Your ref:
Our ref: 22/01943/F
Please ask for: Amy Davies
Direct dial: 01553 616879
E-mail: borough.planning@west-norfolk.gov.uk

Details: **A Proposed first floor side extension over existing garage, Alterations to garage along with internal alterations .
at 82 Hythe Road Methwold Thetford Norfolk IP26 4PU**

I have received a planning application as detailed above but cannot process it until I receive some more information:

TAB826-09

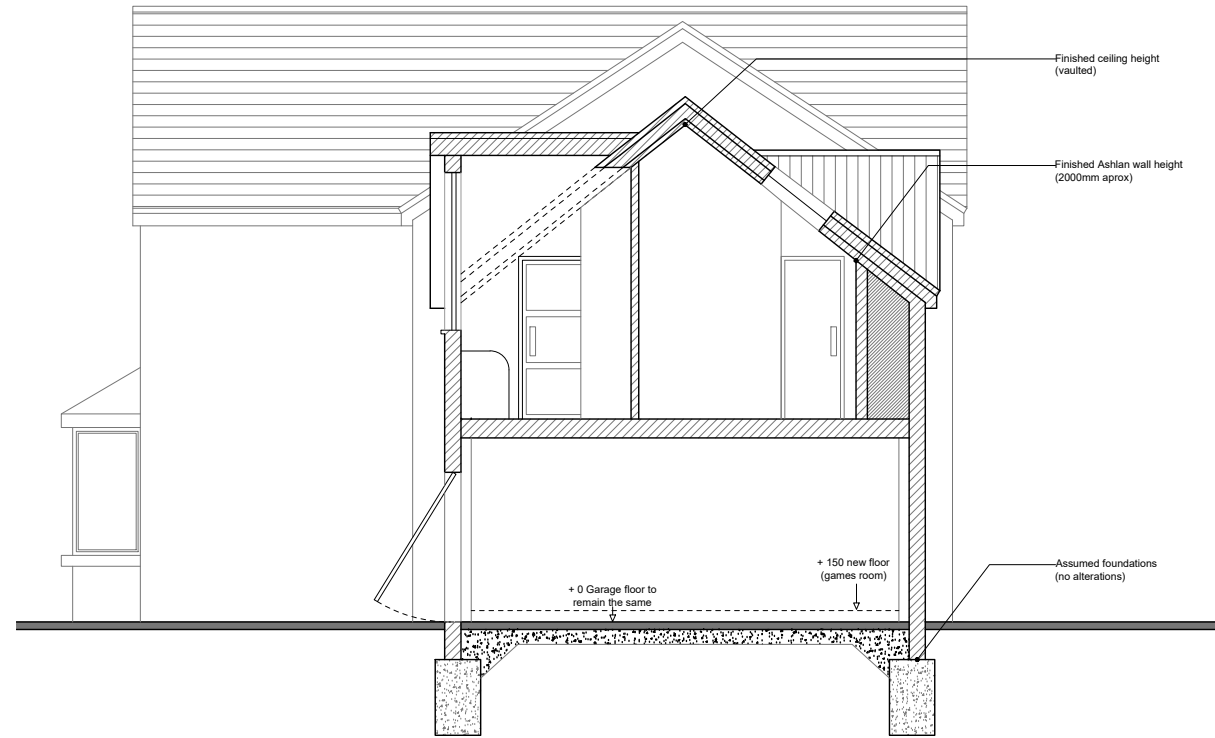
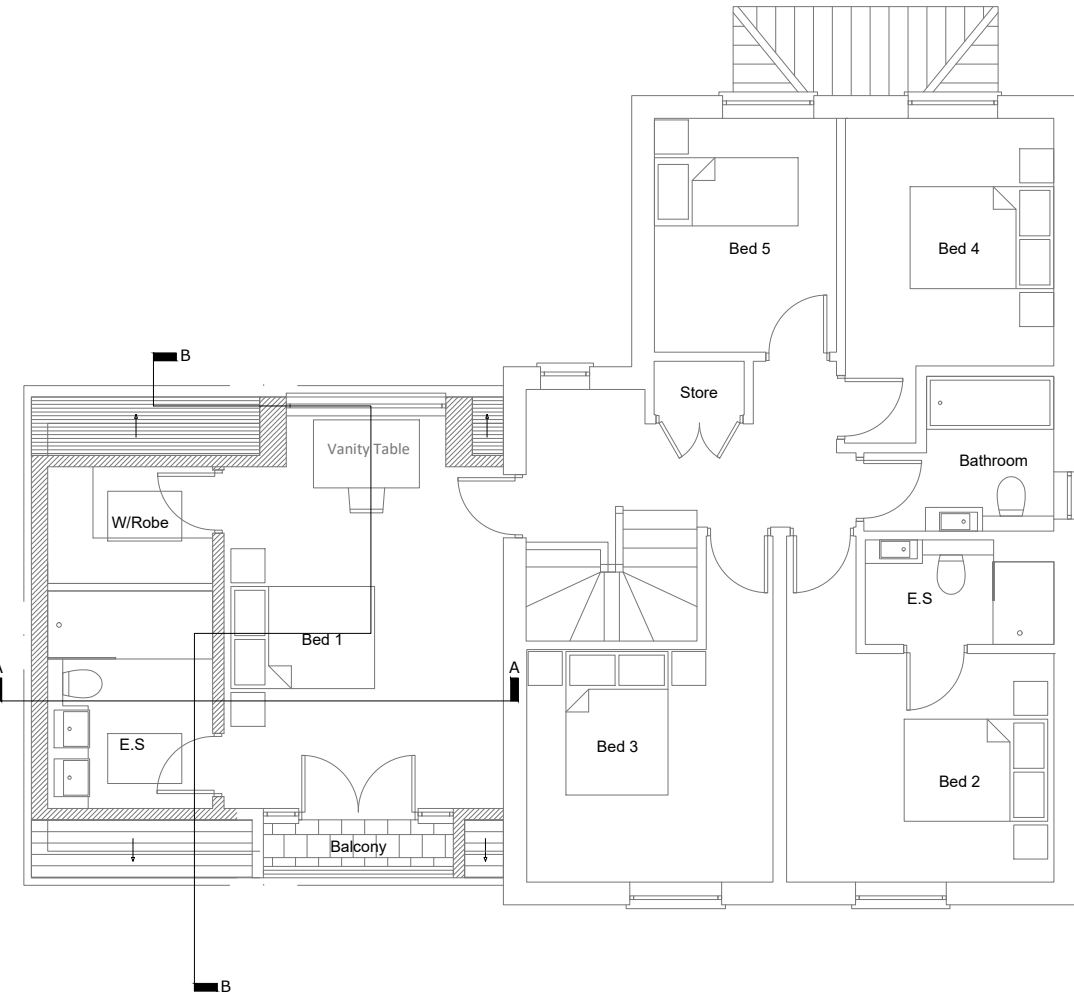
1. Please provide four copies of a drawing, to a recognisable scale, showing a section through the new extension.
2. It appears that on the excising and proposed floor plans they are showing a window and a door but does not appear to be showing on the side elevations please amend and resubmit.
3. Please provide a location plan and a site plan showing the site boundaries with a red line.
